Our Reference: SYD17/01058/02 (A20780642)
DP&E Ref: SSD 8677

**PROPOSED ALTERATIONS AND ADDITIONS TO FAIRVALE HIGH SCHOOL
1 THORNEY ROAD, FAIRFIELD WEST**

Reference is made to the Department of Planning and Environment (DPE) letter dated 11 December 2017, regarding the abovementioned application which was referred to Roads and Maritime Services (Roads and Maritime) for comment.

Figure 3: Bus stops located around the school

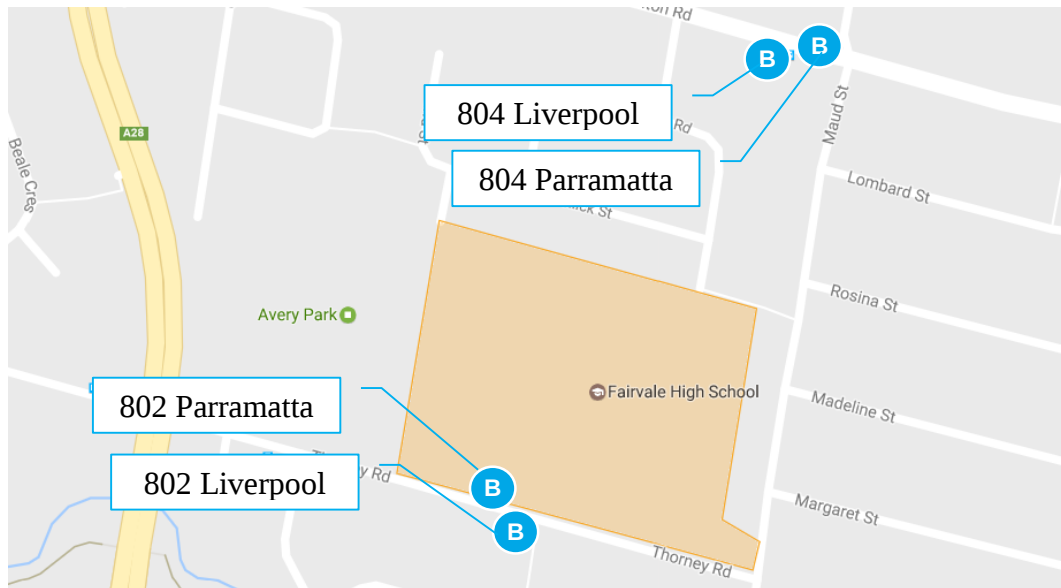
3. The submitted reports show a high proportion of public transport usage for the school. The proponent should consult with TfNSW regarding any proposed/required additional bus services as a result of the development.

Figure 6: Current parking restrictions around the school and number of parking spaces

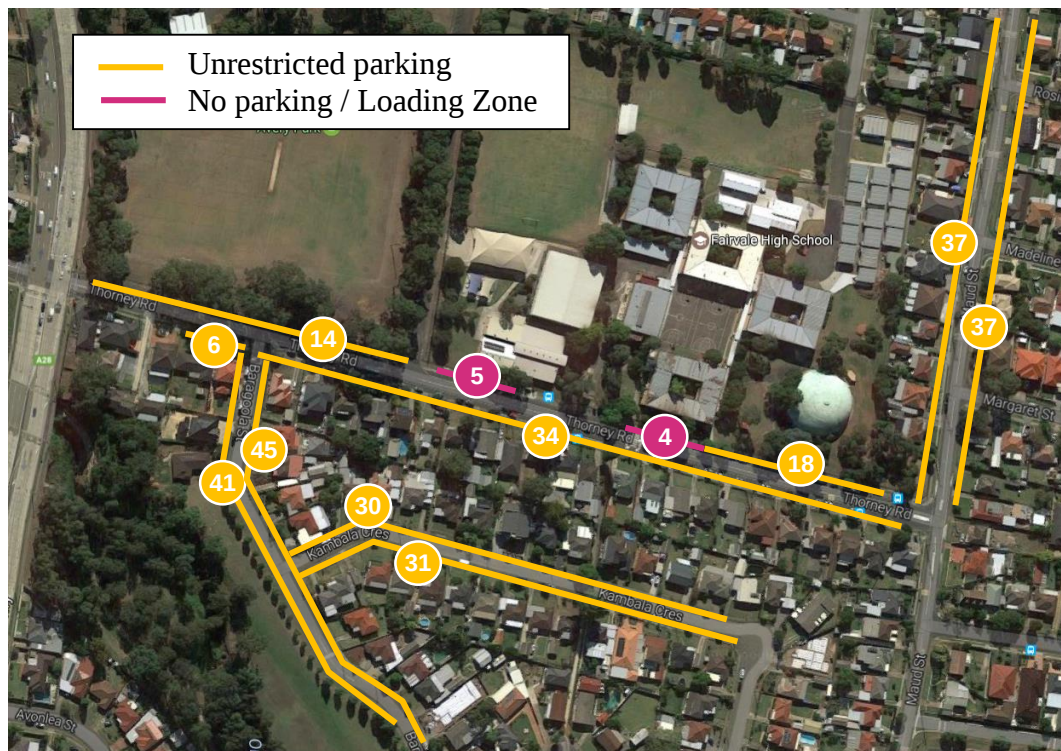
1. It is noted the proposed/provided number of on-site parking spaces is well below the required car parking by Fairfield City Council. Roads and Maritime recommends that a traffic/parking management plan to be provided for the school and approved by DPE showing the above parking arrangement does not compromise road safety and traffic efficiency on the surrounding road network. DPE should also ensure the additional vehicle trip as a result of the development can be accommodated within the area road network.

Figure 14: Traffic modelling extent

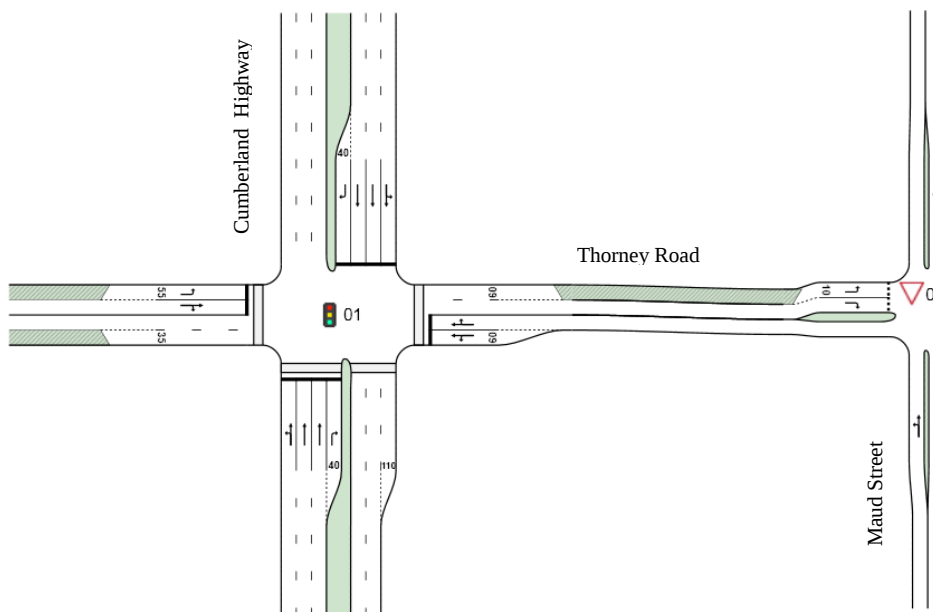
2. The traffic assessment shows delays for vehicles on Thorney Road both approaches at the intersection of Cumberland Highway/Thorney Road. Roads and Maritime recommends DPE consider a dedicated right turn lane on Thorney Road to improve the traffic efficiency.
